EXTRACTS FOR THE ENVIRONMENT PROTECTION AUTHORITY

2. RESPONSES TO ISSUES RAISED ABOUT THE AMENDED PROJECT

Figure 2.4.3 Year 7 (2016 AQA) Source Locations Compared with Year 7.75 (2013 AQA) Source Locations

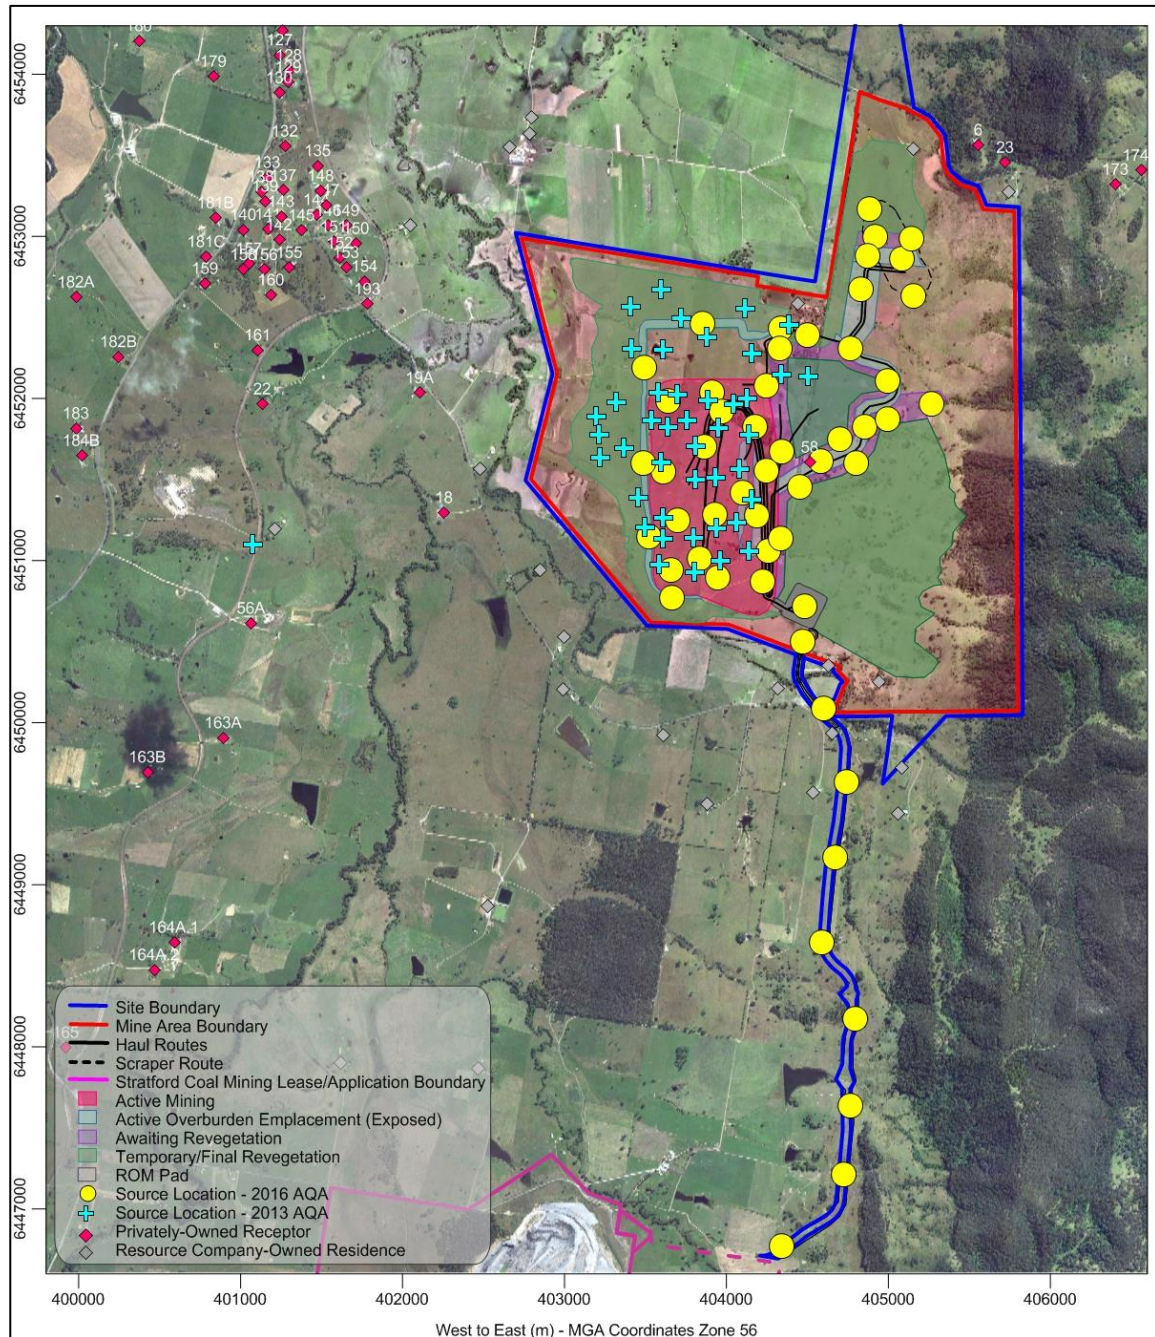
Estimated emissions from the amended project differ significantly from the original project with consequent changes to the assessed impact on sensitive receptors. Reduction in coal processing reduces emissions from this component of the processing.

2013 project		Amended project	
TSP emissions (T / yr)	Year 2.5	928.6	Year 1	267.8
	Year 4.25	1,206.0	Year 4	740.5
	Year 7.75	990.5	Year 7	1,079.9
	Year 13	822.8	Year 10	807.8

Emissions estimation has been done to greater detail than in the original application. For both estimates, emissions of PM₁₀ and of PM_{2.5} are calculated as a fraction of estimated TSP. In the original application, a single value for each was used for all sources. Emission estimation for the amended proposal applies source-specific ratios. The resulting total emission estimate has lesser contributions from PM_{2.5} and PM₁₀ to TSP. The fraction of TSP that is PM₁₀ reduces from 0.39 to 0.29 and that of PM_{2.5} from 0.047 to 0.040.

The estimated total annual emissions for the amendment show PM₁₀ emissions are a smaller fraction of TSP emissions than in the original assessment. Emissions are also reduced as there is less coal handling and preparation.

The use of lower contribution ratios (than used in the 2013 EIS) for PM_{2.5} and PM₁₀ as a proportion of TSP has not been raised as an issue in the EPA's submission. To the contrary, although NSW EPA has noted that there has been a change in the approach to calculating PM₁₀ and PM_{2.5} emissions within the AQA for the amended Project compared with the 2013 Air Quality Assessment (2013 AQA) (PAEHolmes, 2013a¹) their submission notes that the "emissions estimation has been done to greater detail than in the original application. ...In the original [2013] application, a single value for each [PM₁₀ and PM_{2.5}] was used for all sources. Emission estimation for the amended proposal applies source-specific ratios."

It is therefore not possible to make a like-for-like comparison between the scenarios and outcomes of the two assessments as all of these changes will have influenced the predicted concentrations, not just total emissions.

The total TSP emissions are lower in the 2016 AQA in all years except for Year 7, which has a marginal increase in TSP when compared with Year 7.75 from the 2013 AQA. **Figure 2.4.3** shows the source locations used in the 2013 AQA for Year 7.75 compared with the source locations used in Year 7 of the 2016 AQA. It is apparent from this figure that the source locations in the 2013 AQA were closer to residences than those in the 2016 AQA. This alone explains the lower predicted concentrations for the amended Project compared with the 2013 Project.
